Offshore Wind Farms

EAST ANGLIA ONE NORTH

EAST ANGLIA TWO

Issue Specific Hearings 14 (ISHs14)

| Figure | 22.5.1c                 |                    |        |

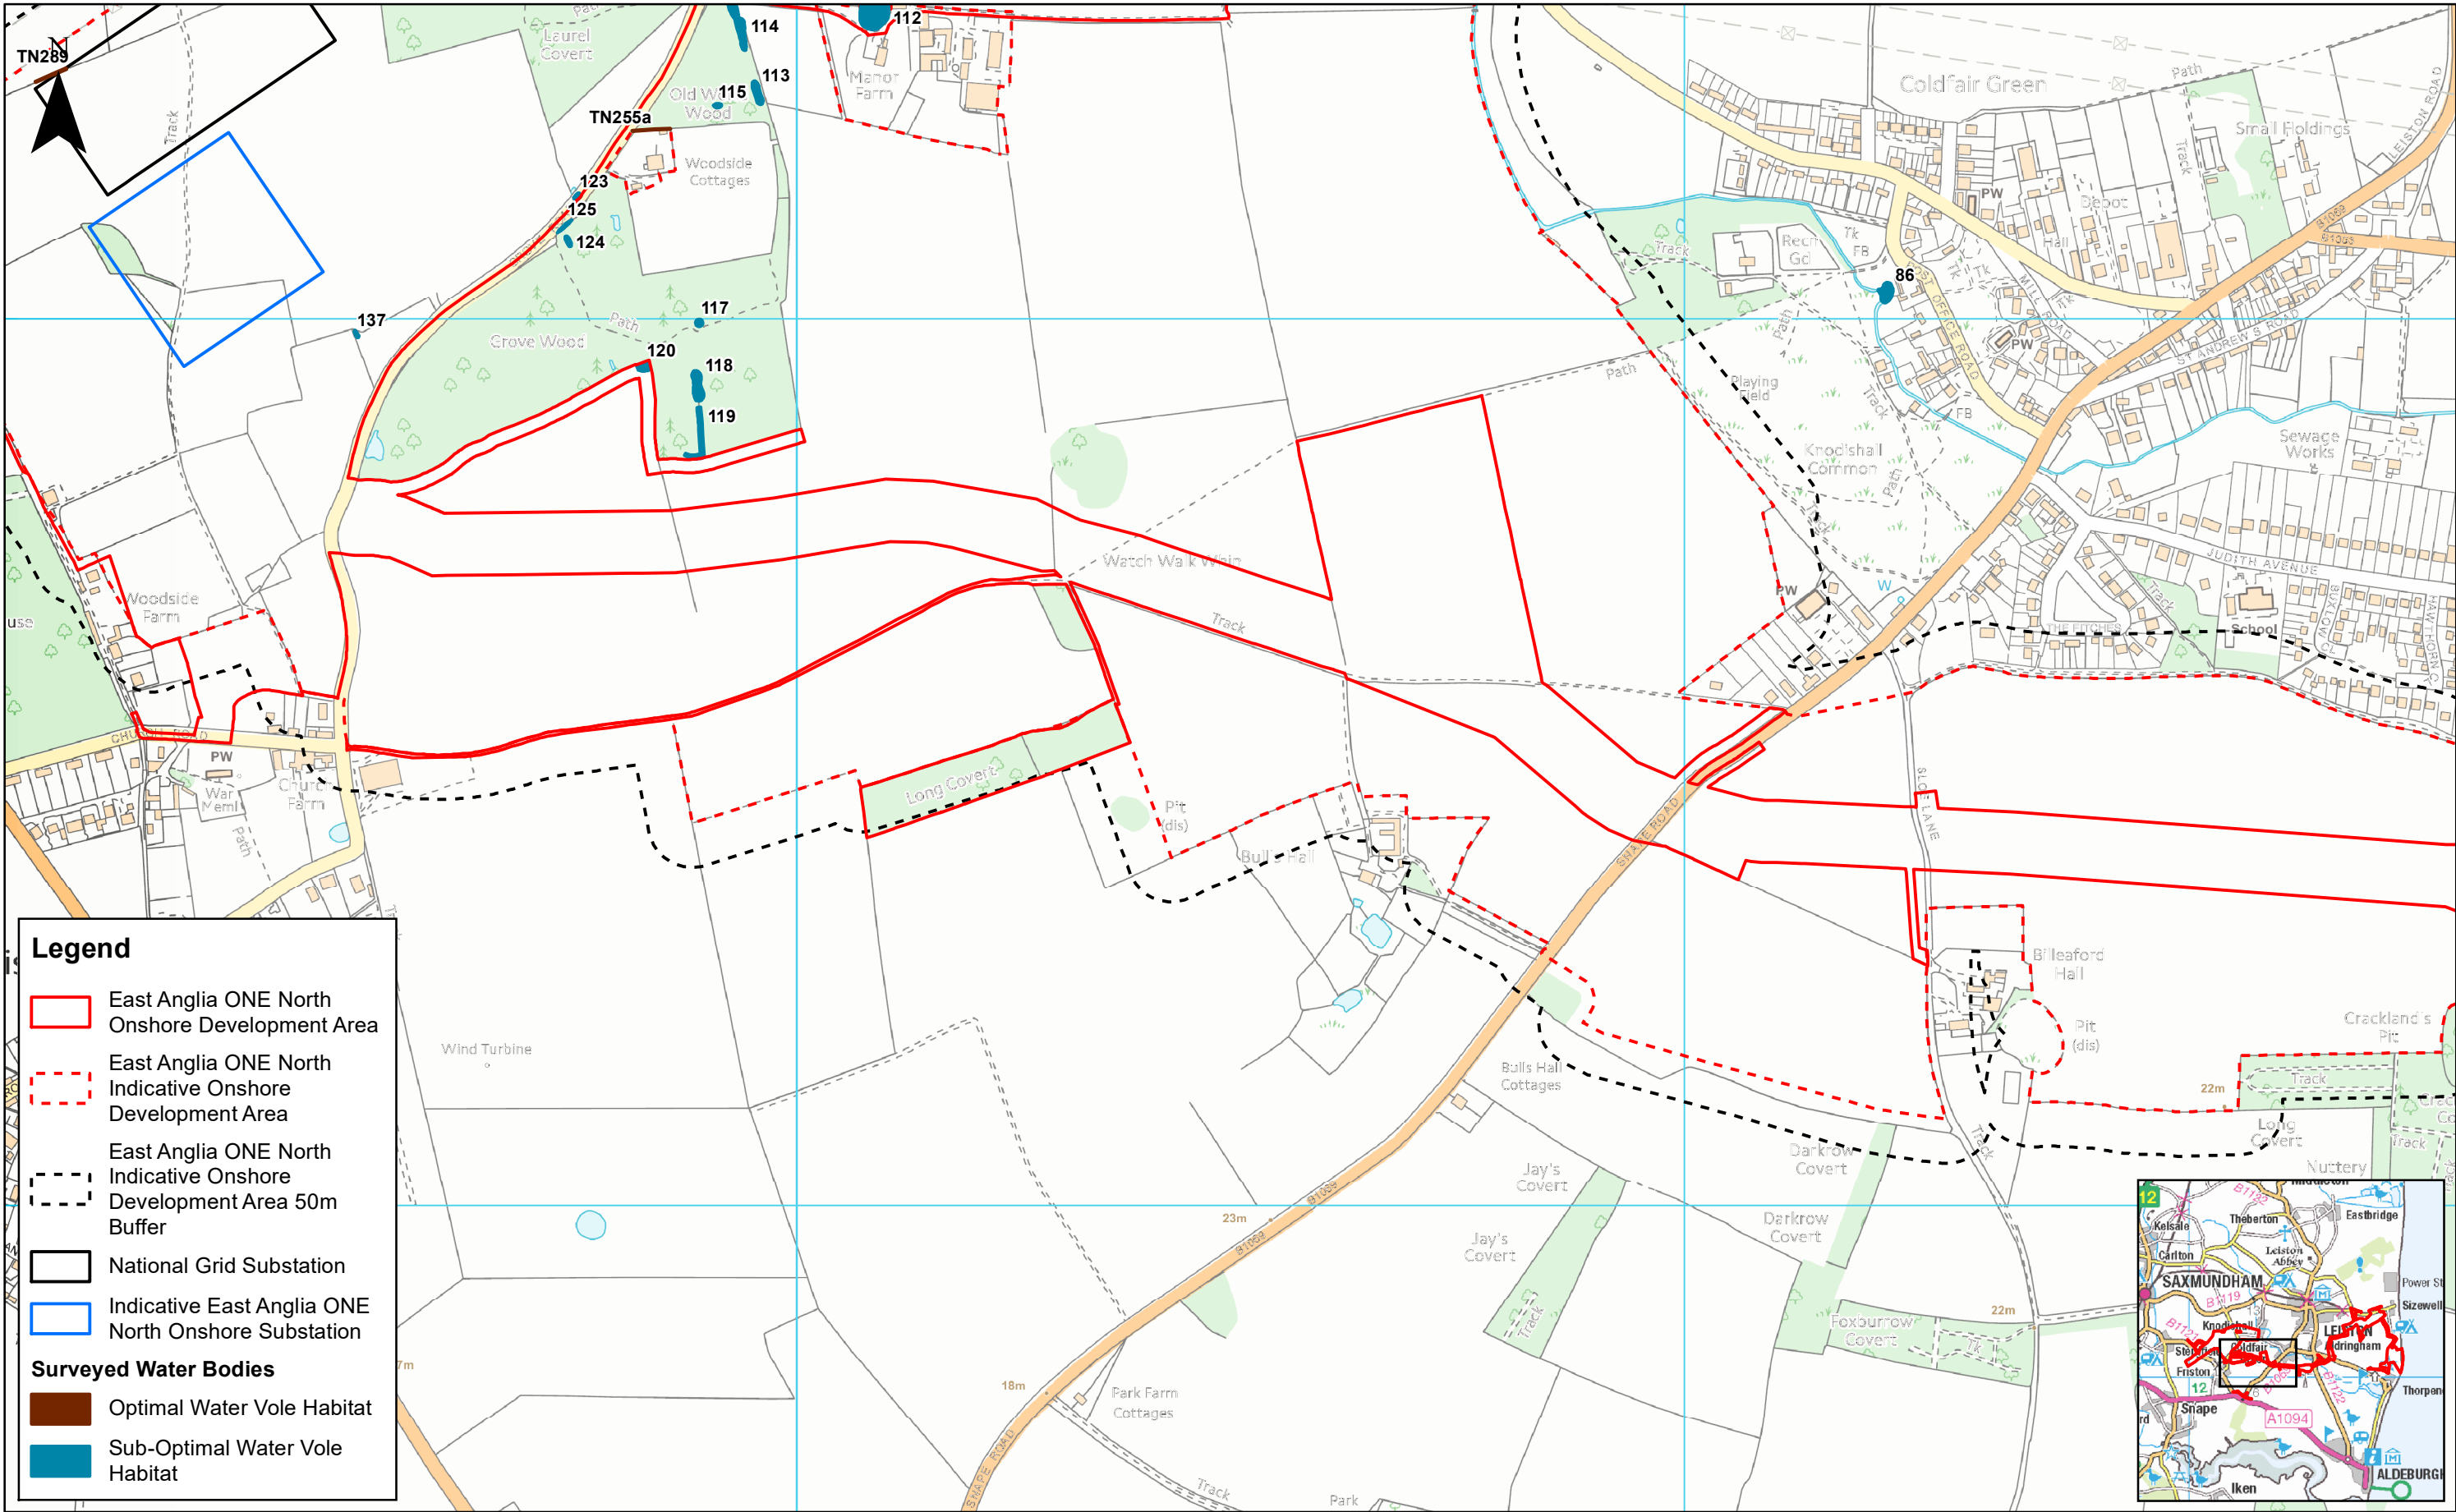
1 b SEAS has repeatedly said that protected species are not confined to SSSIs. The mapping supports our view that the Applicant's surveys are not adequately picking up significant species. In some case, the season of their surveys is wrong. For instance, reptile mats were installed last week (5th March 2021), which is too early. Surveying woodland for wet status in snowy February is also too early.

5 c The Applicant's survey was carried out at the wrong time of year and cannot be adequately concluded until May. In addition, the whole woodland should be surveyed, not just the order limits. The reason we insist on this matter here is that the crossing will more deeply affect a wet woodland. Wet woodlands are sensitive to changes in climate conditions and therefore this woodland is unlikely to recover from the removal of a large section of its trees, disturbance to soils and changes to hydrological conditions.
